Our Case Number: ABP-317121-23

Re: BusConnects Swords to City Centre Bus Corridor Scheme
Swords to Dublin City Centre

BusConnects Swords to City Centre Bus Corridor Scheme
Bord Pleanála Case reference: HA06D.317121-23

Our response to NTA observations on our submission.

BCIDB-JAC-STR\_GA-0002\_BR\_00-DR-CB- 0104

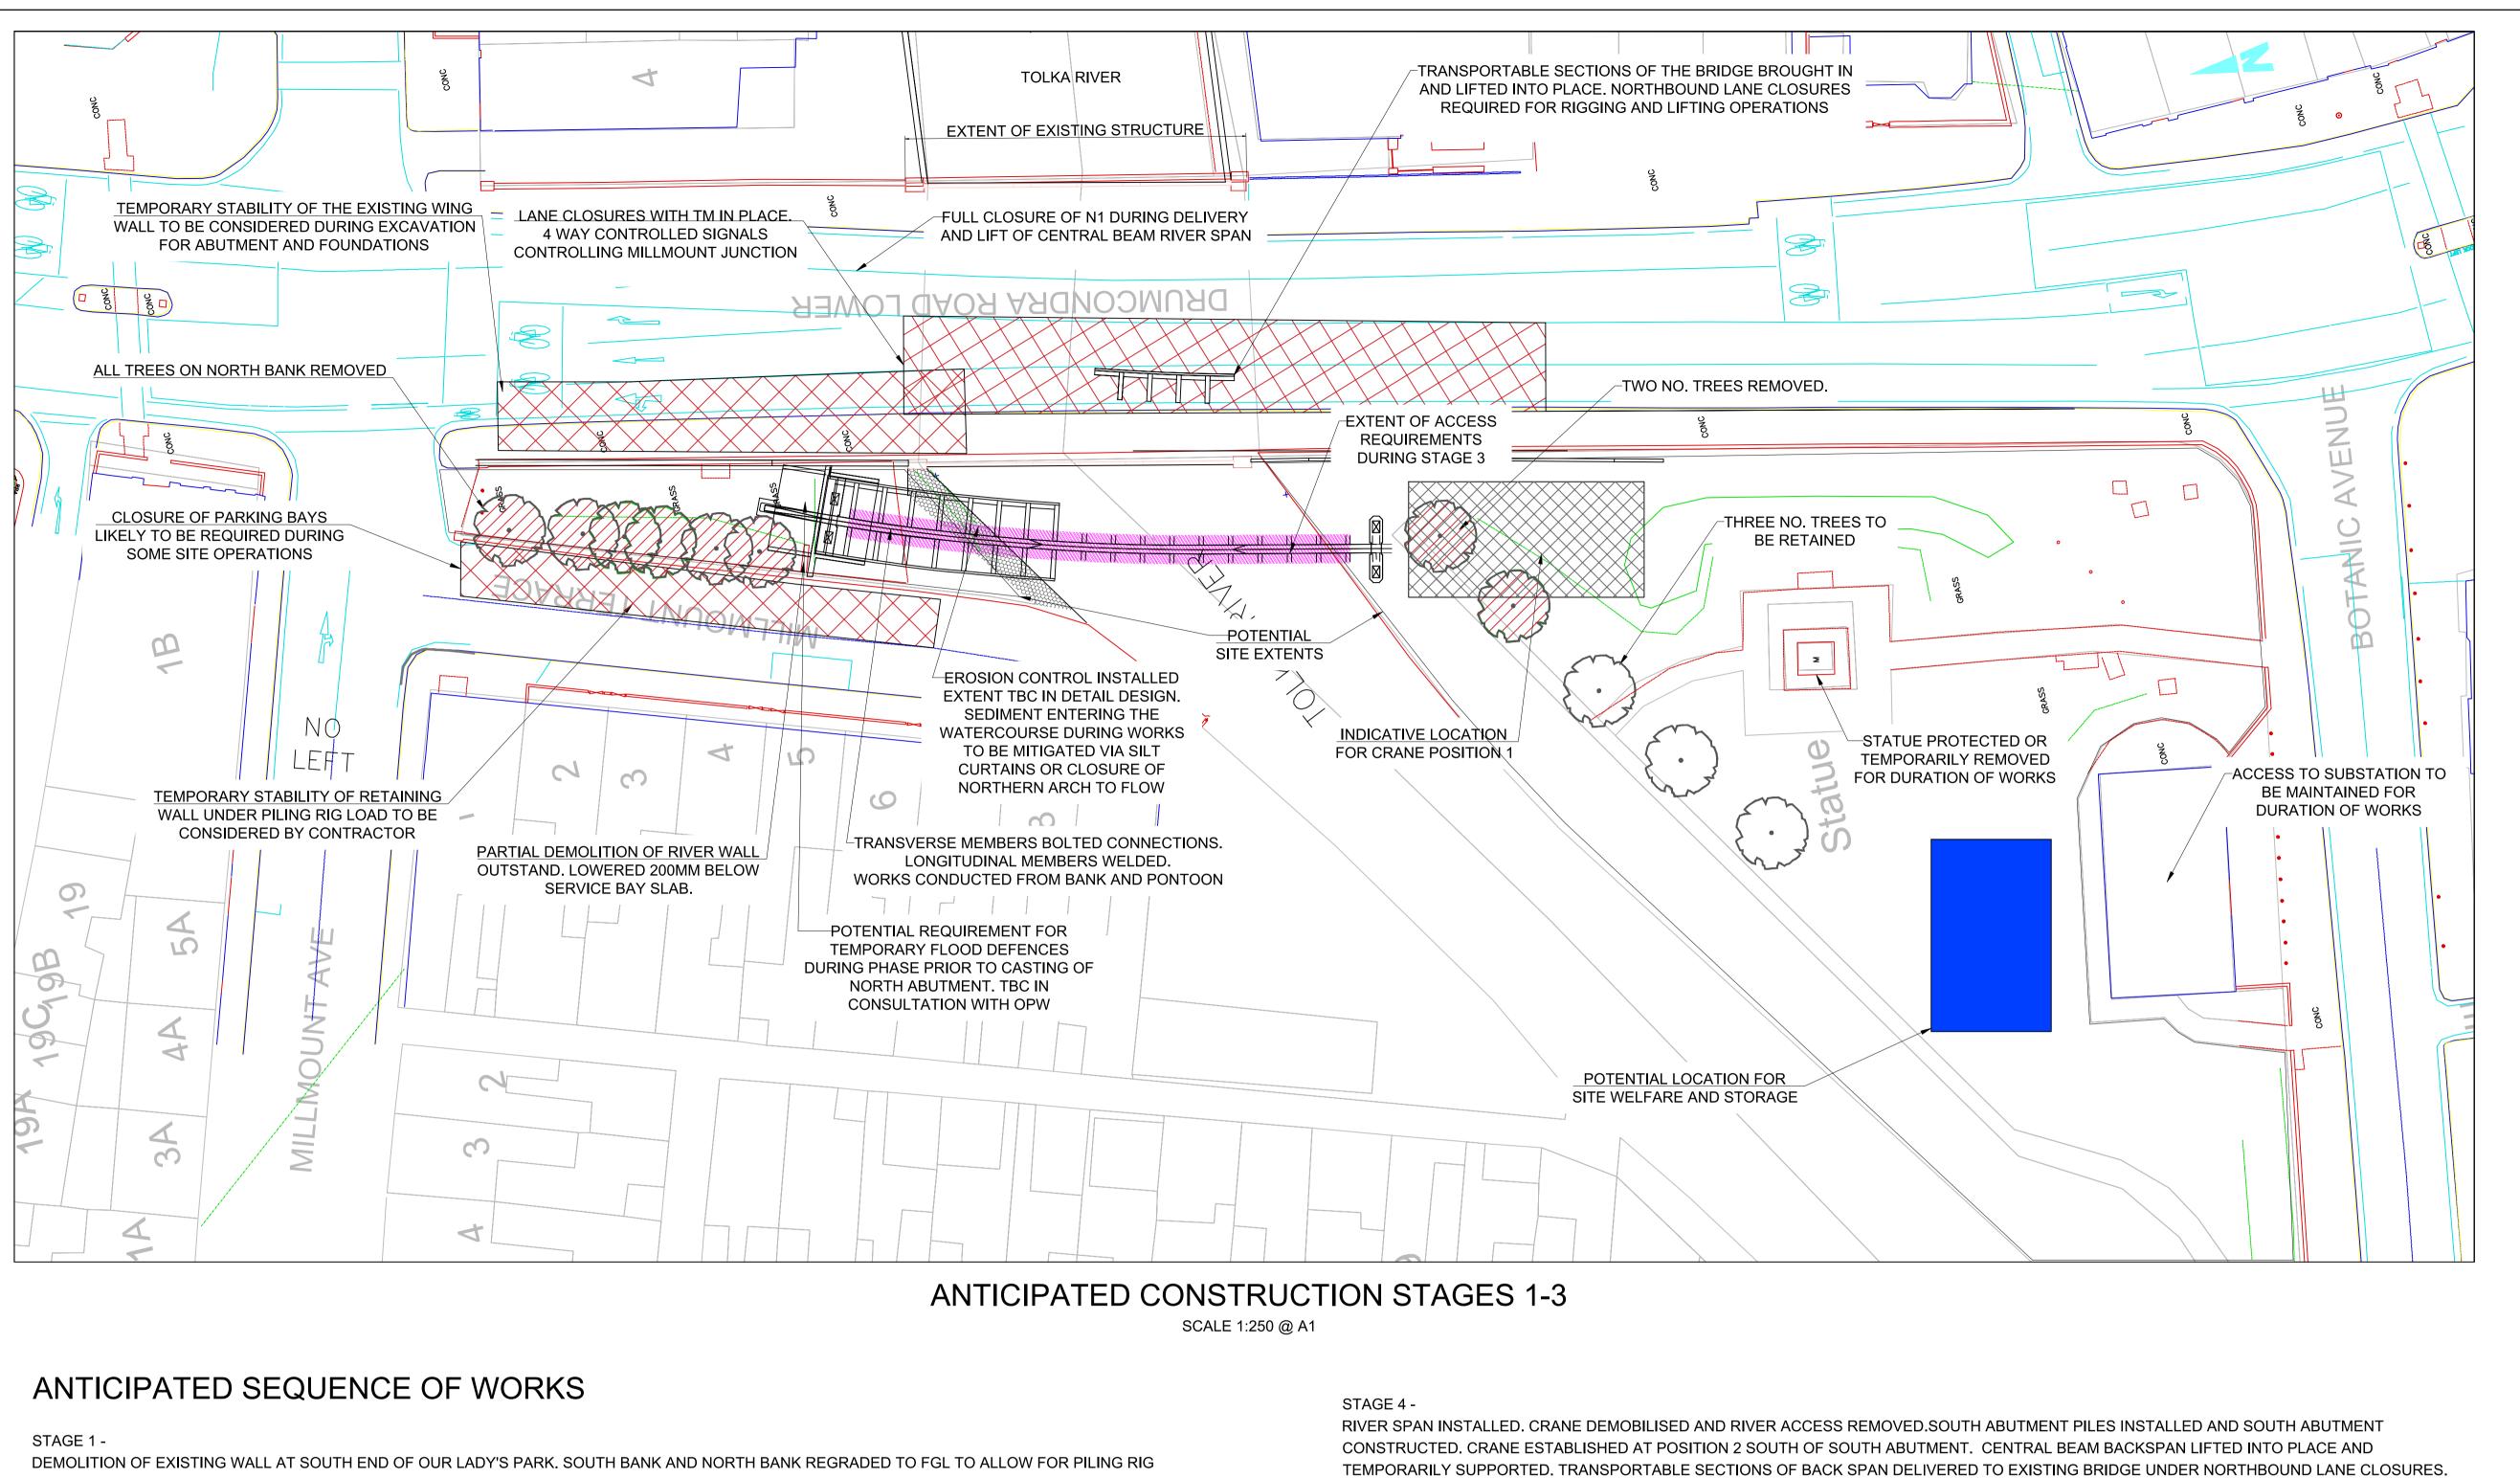
The initial proposal was to widen the existing bridge. The bridge and wall along the Park are consistent with bridges and walls along Drumcondra Road - St Patrick's Campus, Tolka Bridge, Clonliffe College, Binns Bridge) comprising cut stone walls and granite capstones. In the case of the recent realignment of the wall at St Patrick's College, the cut stone wall was fully reinstated.

Without delving through the enormous documentation, why was it not feasible. Cost? We could have retained a footpath along the Park and bridge. Now we are faced with option of no kerbing between the existing bridge and the bus lane on one side and a with a new bridge on the other, rendering the visual amenity of the current bridge practically invisible. The NTA itself finds that the no kerb "will require strengthening of the spandrel wall to accommodate the increase in surcharge. Mitigation measures will also be introduced to reduce the risk of collision with the substandard western parapet."

The proposed new bridge has made no effort to demonstrate any empathy with the historic boundary treatments of the surrounding area contrary to Volume 4 Part 3 Chapter 16.3 of their Environmental Impact Assessment Report (EIAR) The proposed bridge will have white painted steel railings and glass panels which will be much more open to graffiti than the traditional walls in the Drumcondra area.

How can the NTA assert the above comments? The sizable area between the new bridge and the existing Our Lady's Park wall and also the area under the new bridge will for the most part become unusable. Per NTA *The distance between the deck soffit and the ground varies. A minimum clearance of 1.5m is provided at the abutments.* This would not allow for standing headroom. Our Ladys Park is already quite a small area. The new bridge will extend west as far as the current location of the statue. The amenity of the park will be greatly reduced.

Our Ladys Park at this location is currently a very open and well overlooked by pedestrians. We firmly believe that the area concealed by the new bridge and between it and the existing wall will likely attract anti-social behaviour.

Regarding the suggestion to widen the existing bridge, it was determined in the options report that it would not be feasible to directly widen the existing masonry arch structure and therefore a new independent structure is to be provided to accommodate the wider highway cross section desired at this location.
